**REQUEST**

Current Zoning: N1-B (neighborhood 1-B)  
Proposed Zoning: R-8MF(CD) (single family residential, conditional)

Approximately 15.93 acres located on the west side of Milhaven Lane, south of Juniper Drive, and east of Interstate 77.

The petition proposes a residential community containing a maximum of 90 single-family attached dwelling units.

CONCEPTUAL SITE PLAN
REZONING PETITION #2022-218

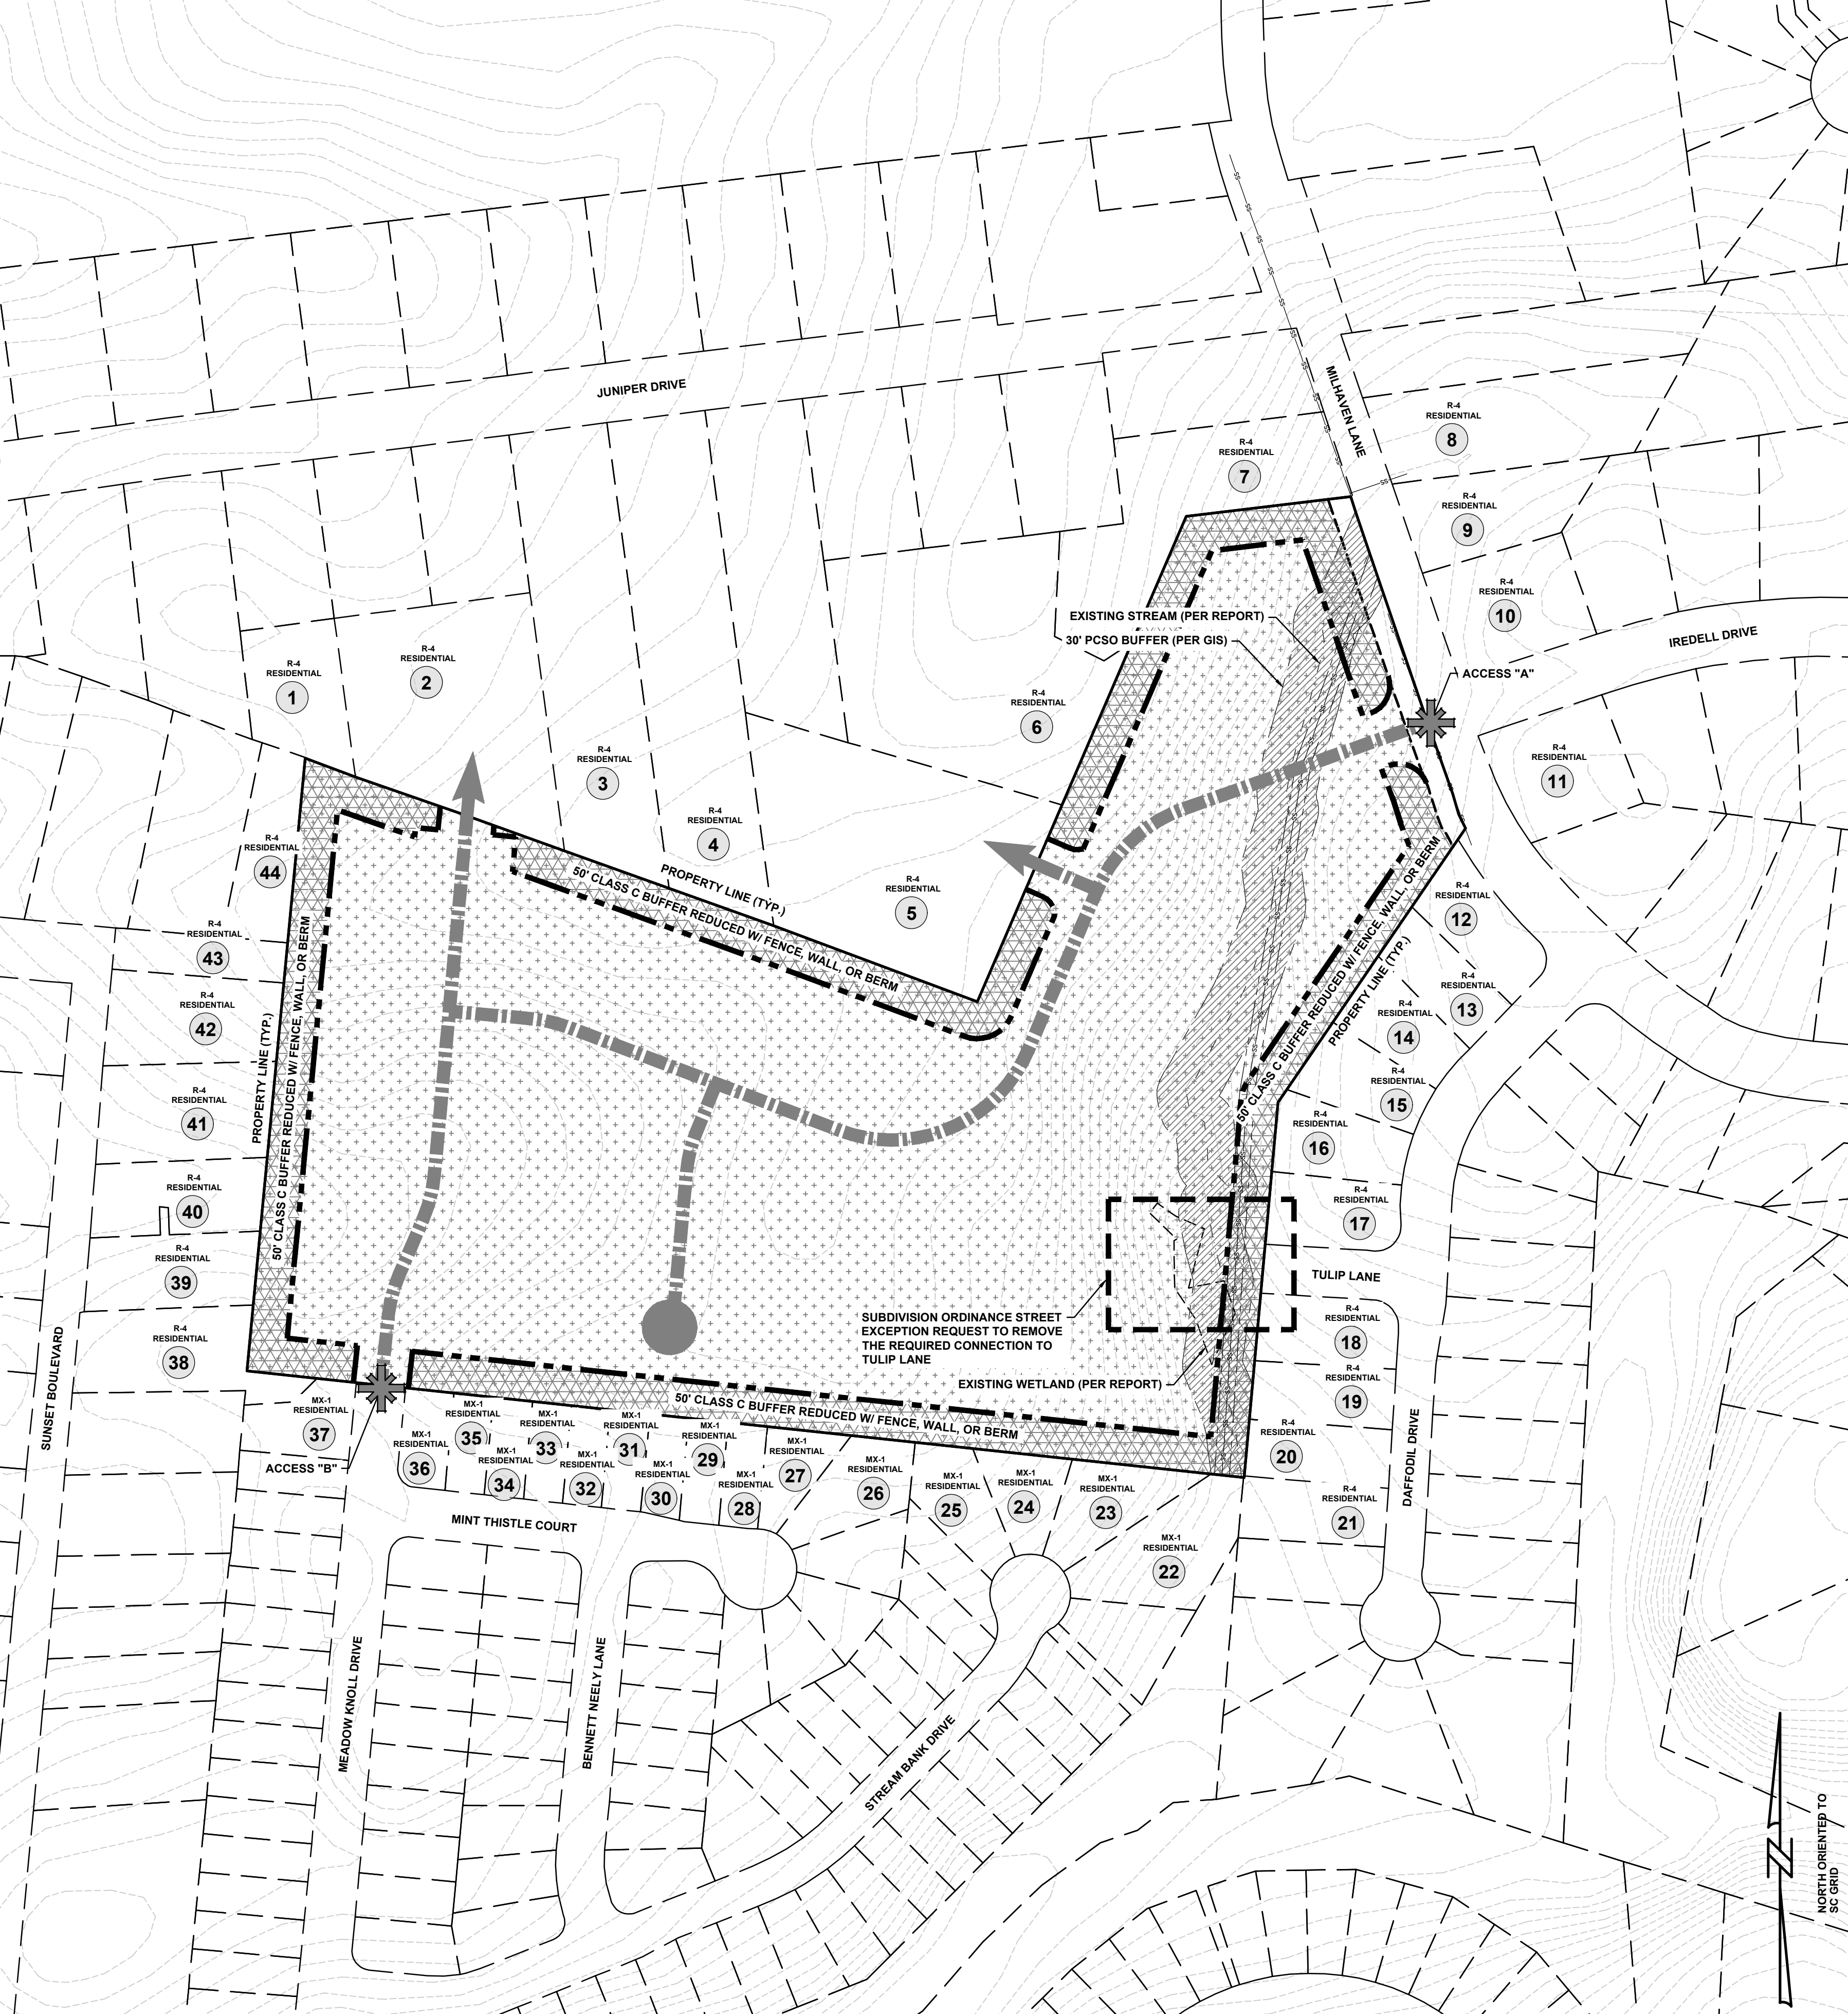
1. Label and dimension 8-foot planting strip and 5-foot sidewalk along internal public streets.
2. Revise notes to say transportation improvements will be approved and constructed before the site's first building CO instead of 25th CO.
